**Re: Objection to MP08 0244 MOD 1 -
Modification Request for Mixed Used Development at 23-37 Lindfield Avenue
and 11 Havilah Lane, Lindfield**

3 SHADOW DIAGRAM - 21stDEC_3PM
5003 SCALE1 : 650

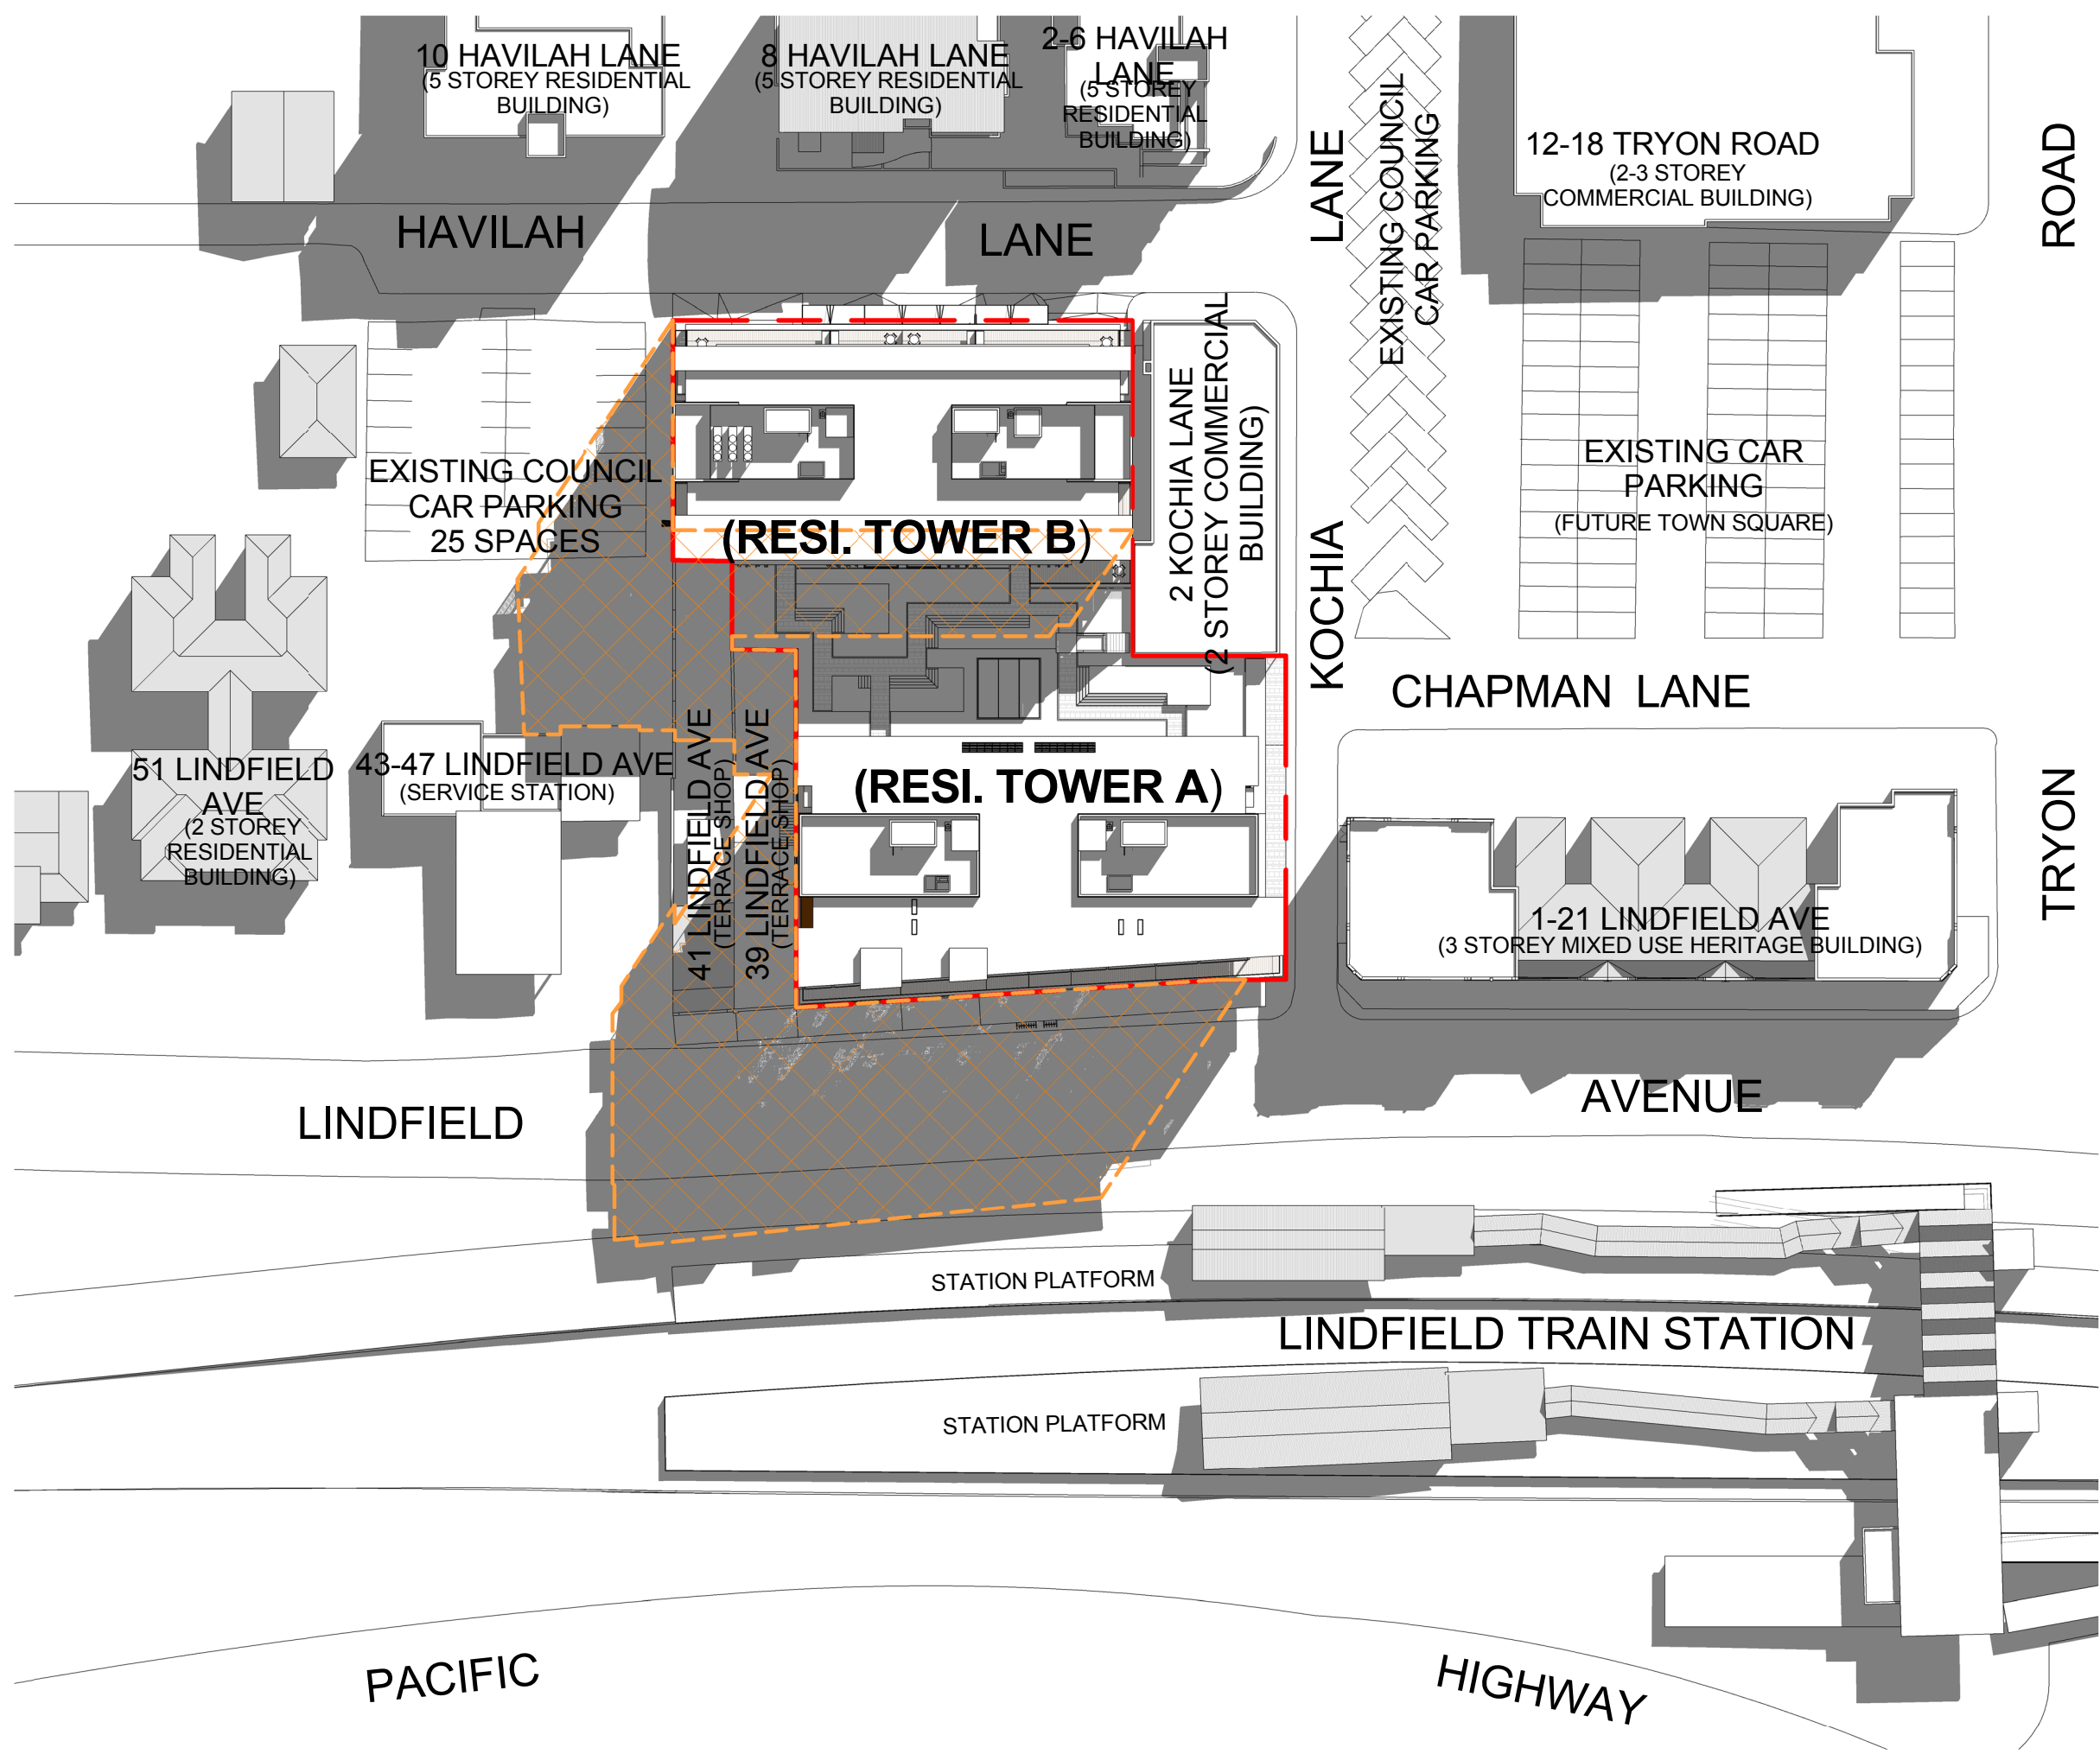
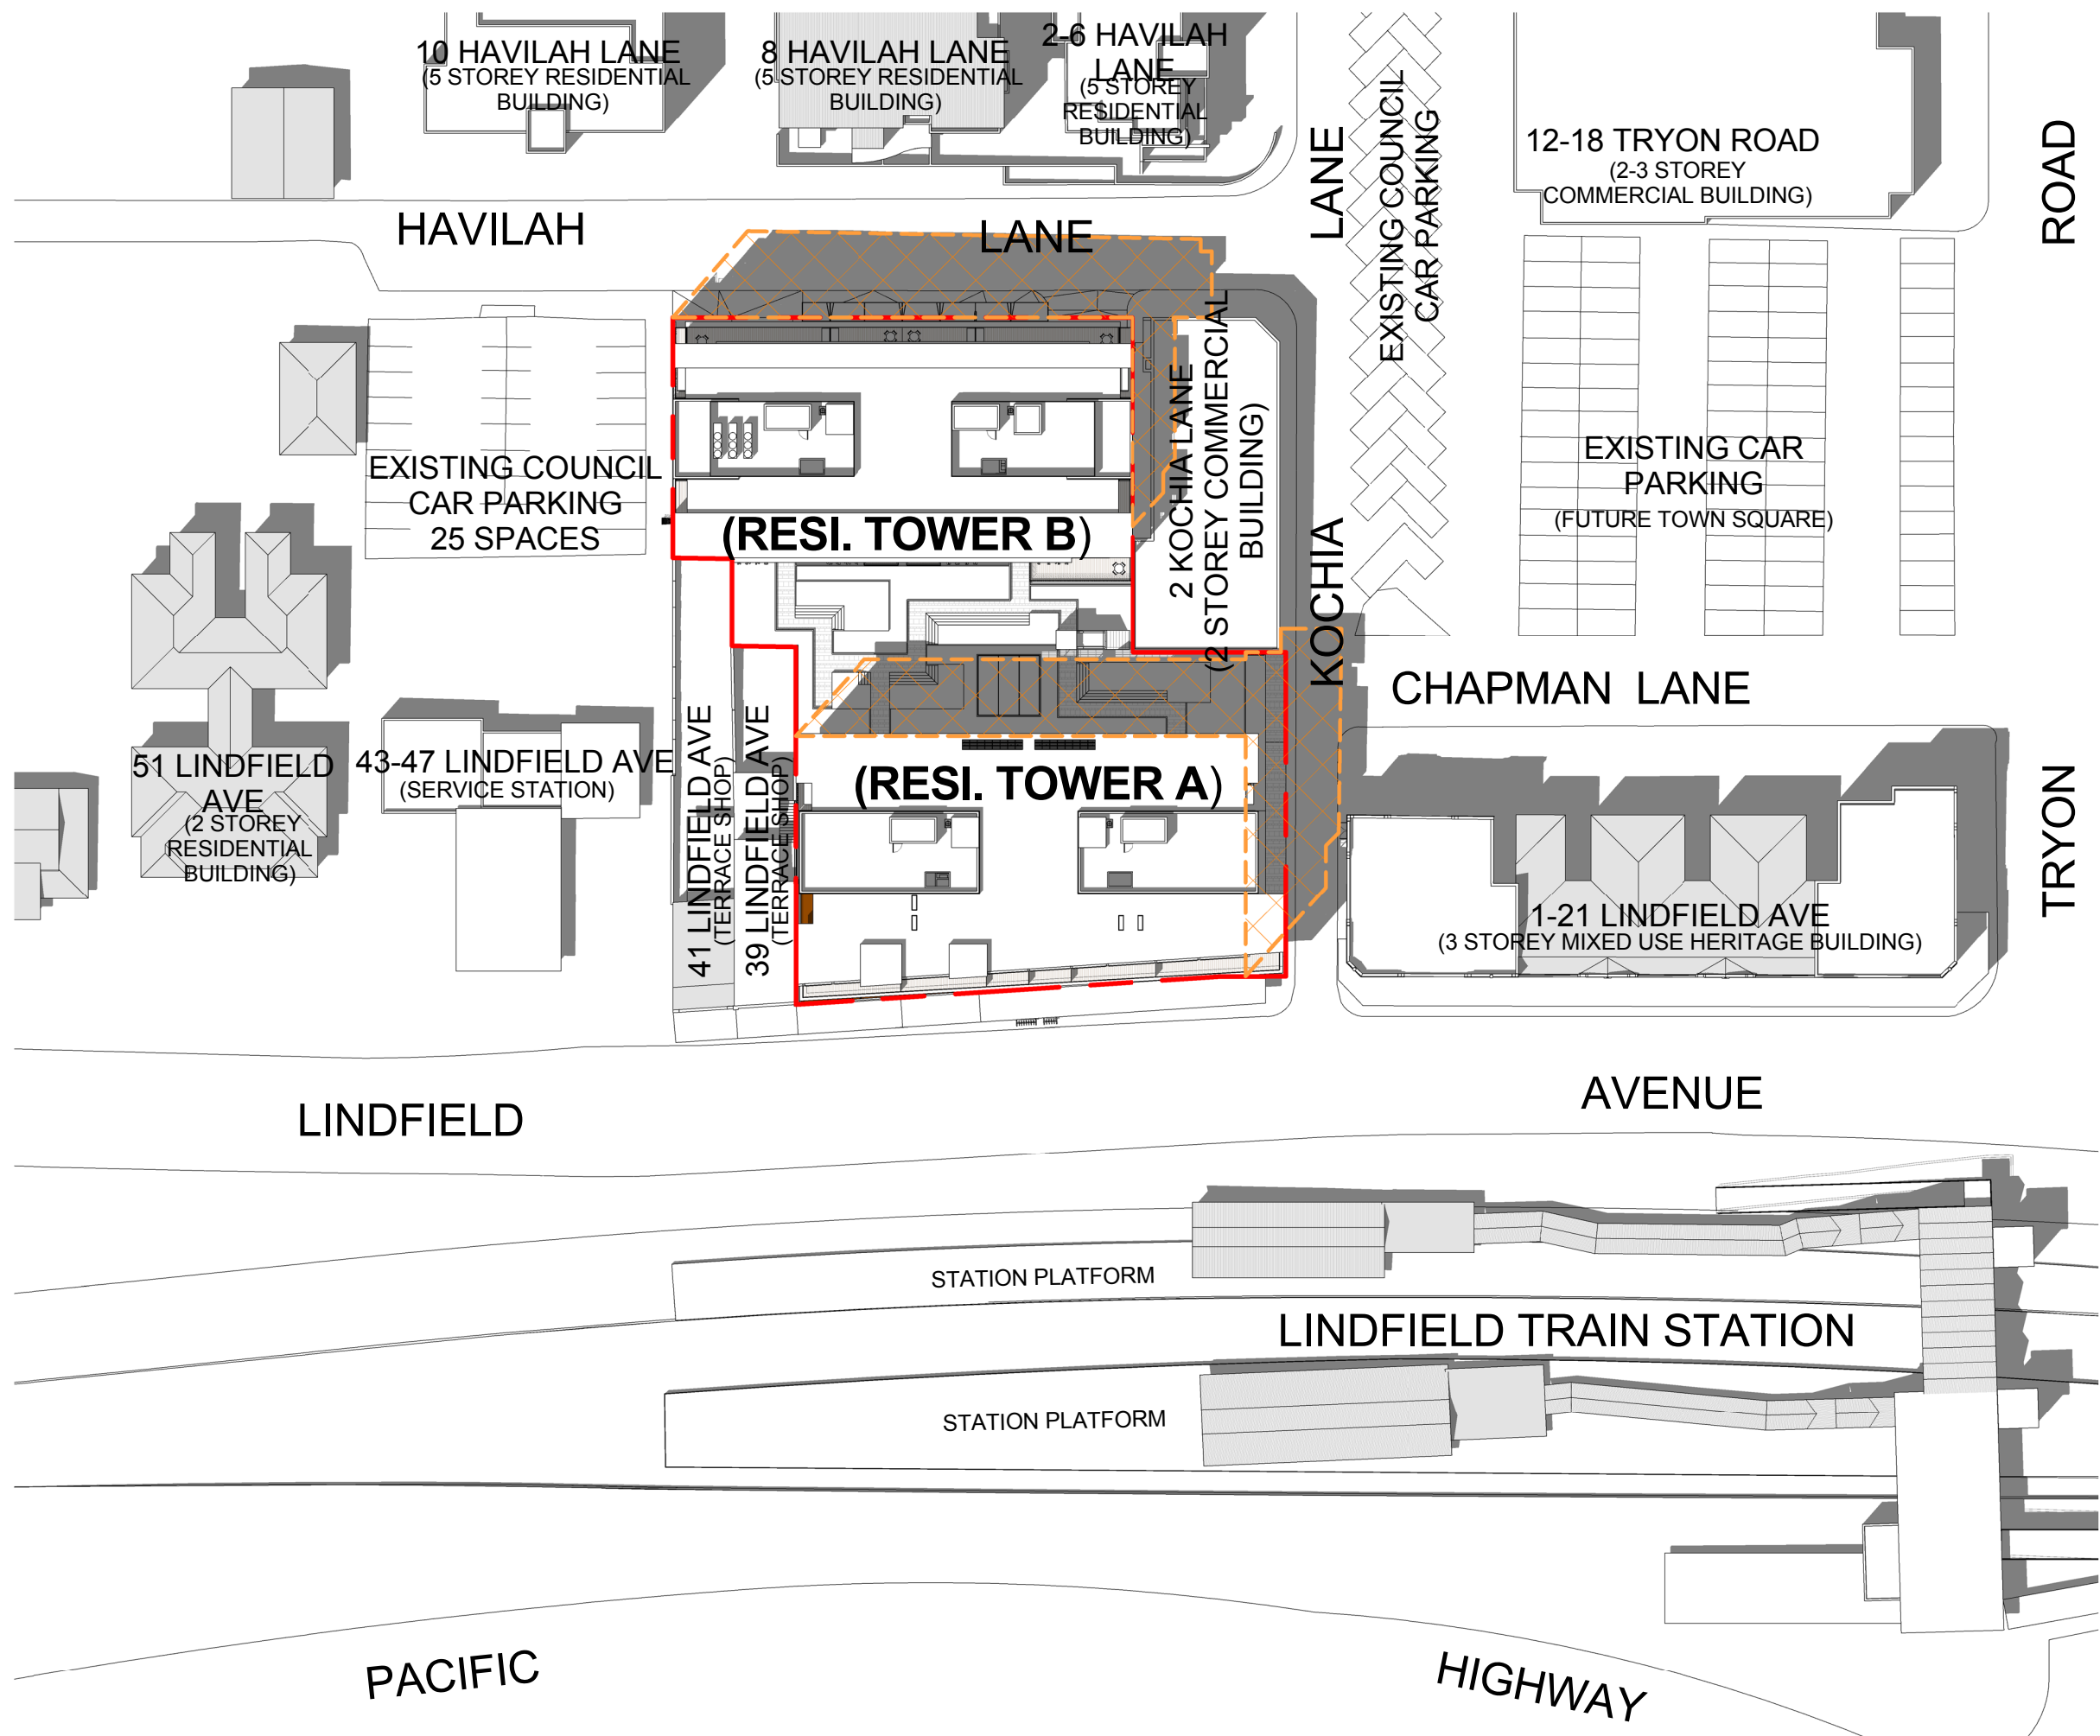
3. The **additional storeys create new adverse shadowing**:
 - (a) for **residents in the existing apartment blocks along Havilah Lane**, particularly after 3pm;

- (b) for the **popular outdoor café and central Lindfield hub area at 12 Tryon Road** in the afternoons, particularly in winter; and

(c) for all commuters on the city-bound Lindfield rail platform - instead of 50% of the year as was initially approved, this platform at the station will now be in shadow in the mornings for 75% of the year.
